# CITY OF ALBUQUERQUE

**Planning Department  
Transportation Development Services Section**

Re: Certification Submittal for Final Building Certificate of Occupancy for  
Daskalos Manual, [H-18 / D45]  
5504 Manual Blvd NE  
Architect's Stamp Dated 03/03/06

PROJECT TITLE Daskalos Menaul 5504 MENAUL BLVD. NE ALBUQUERQUE, NM		JOB NO. 0458		DRAWN BY: JS	
PROJECT MANAGER JOHN STERNI		SHEET TITLE SITE PLAN/DETAILS

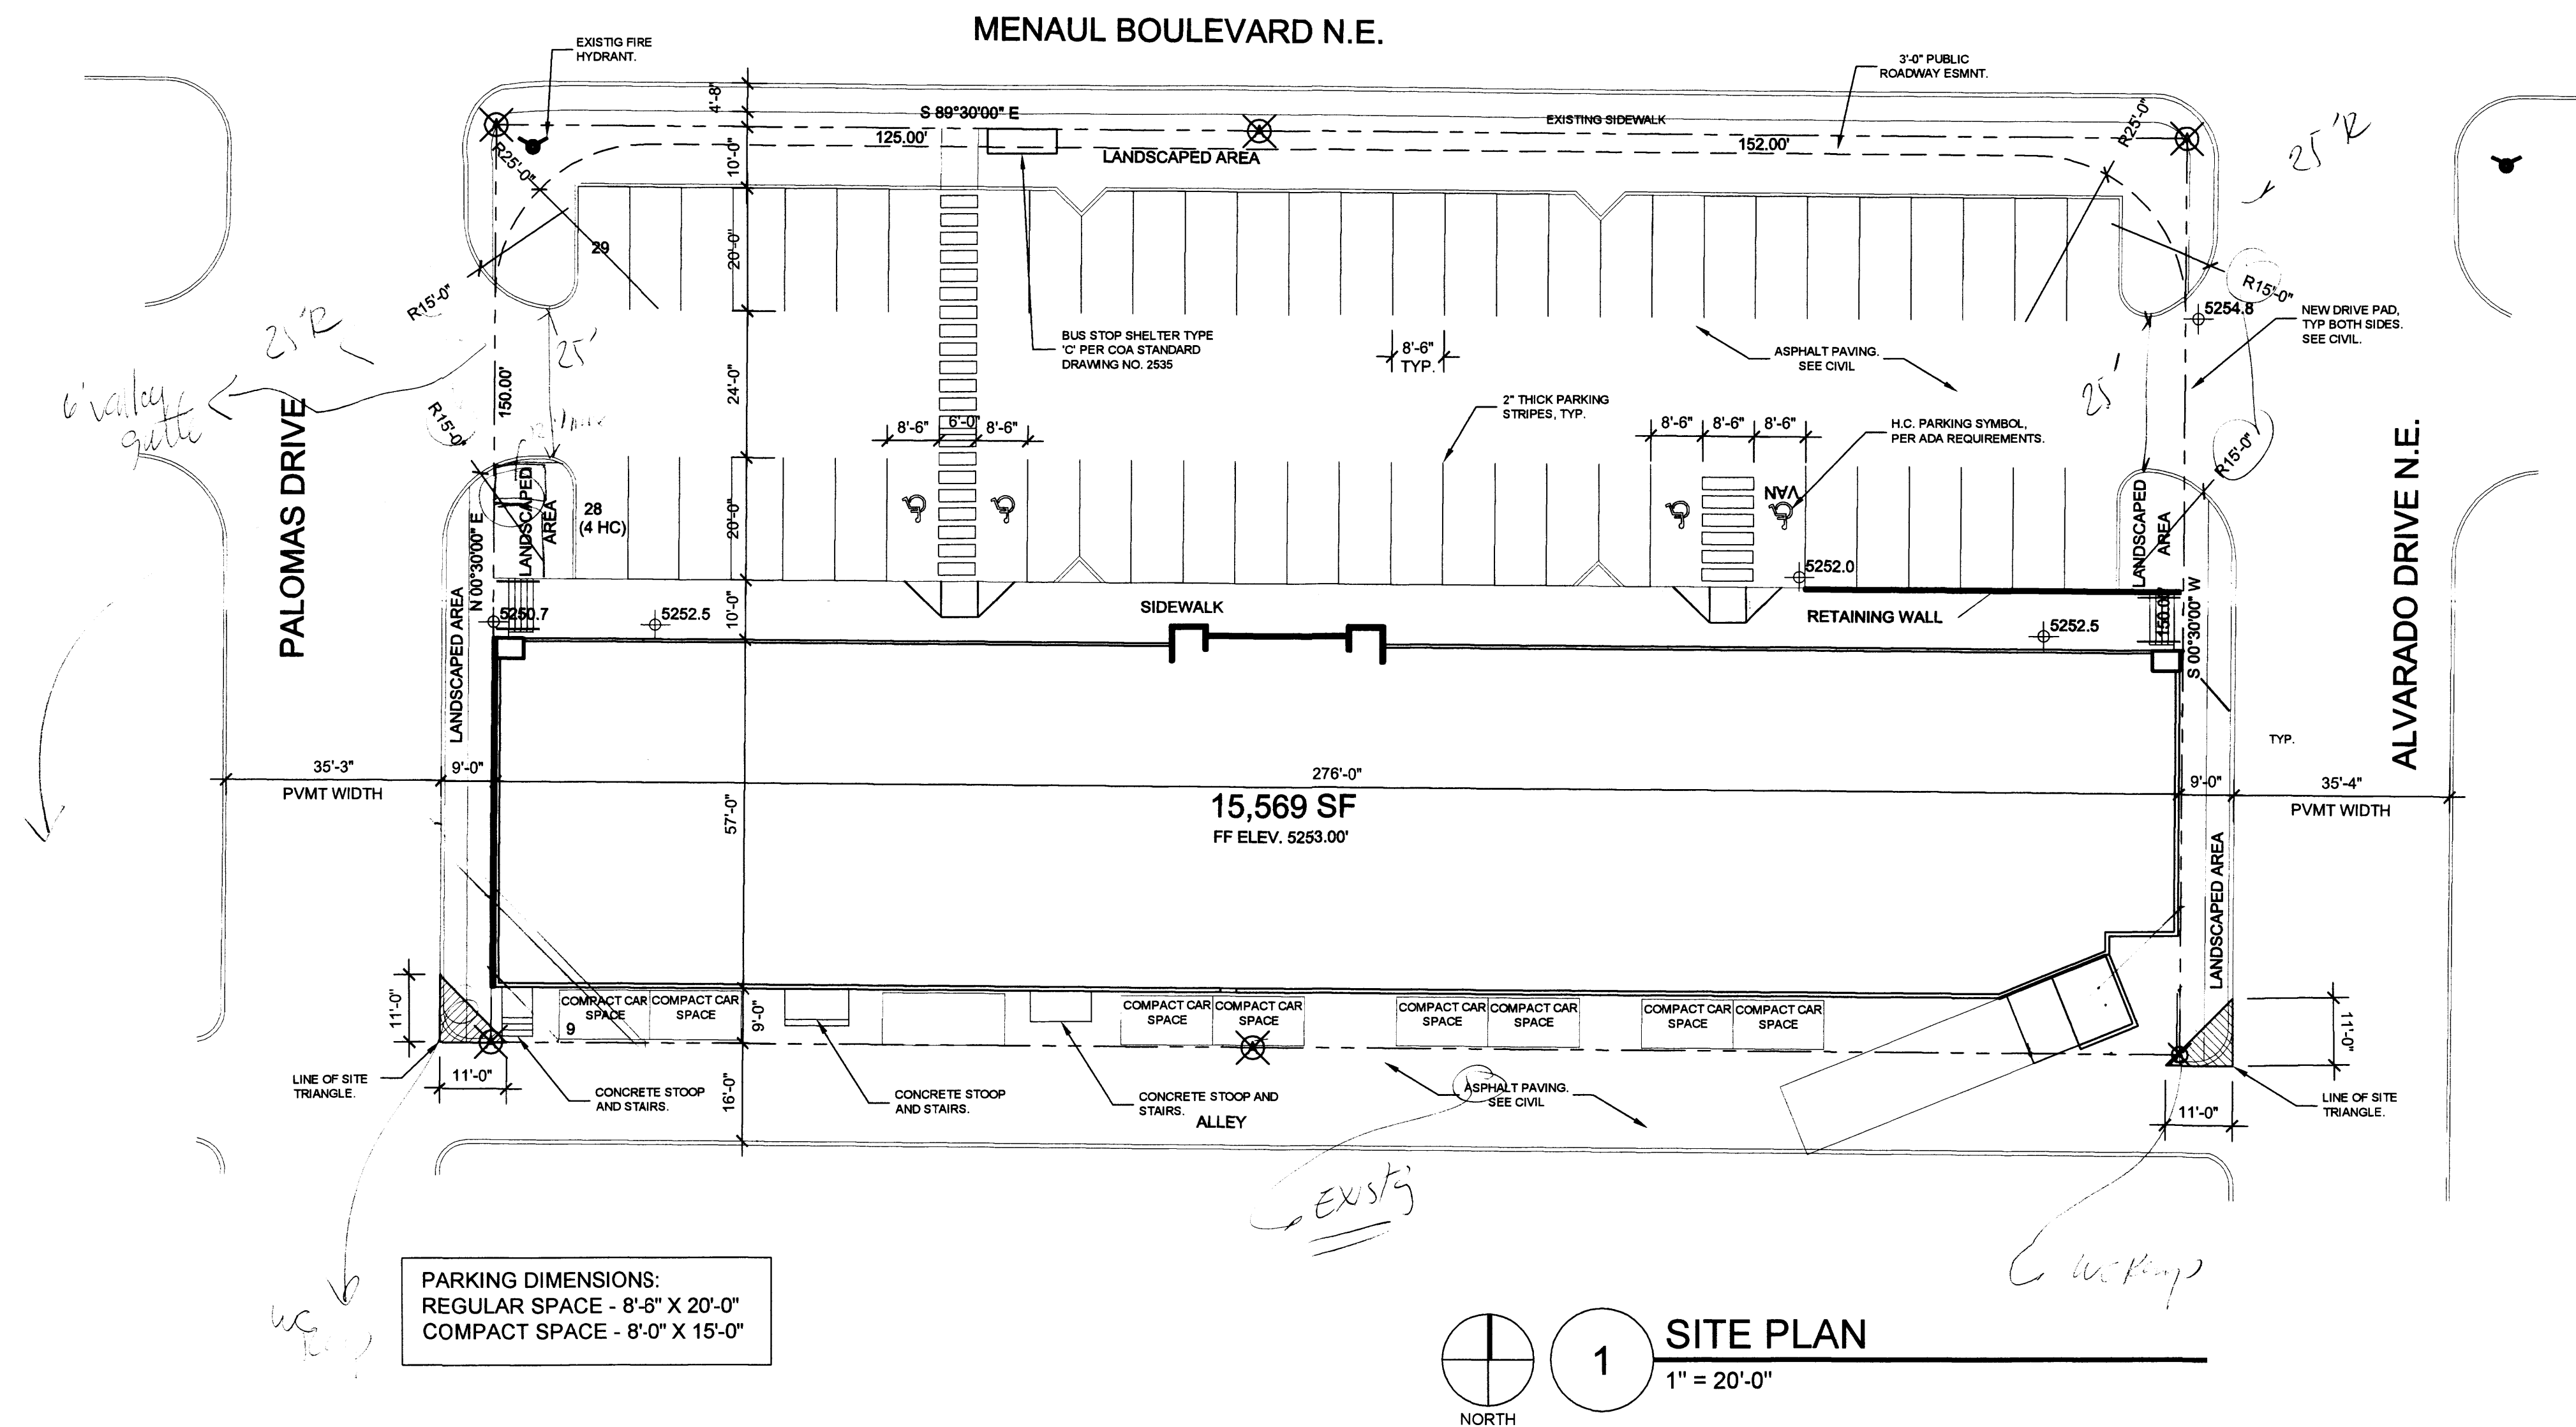
The TCL Site Plan submitted for Final C.O. needs to reflect the approved Work Order (CPN 761981). All infrastructure approved by work order has not been reflected correctly on the Site Plan, especially the widths, radiuses, sidewalk connection and wheel chair ramp fronting Palomas and Alvarado. You will need to redlined all changes, initial and date by the designer-of-record.
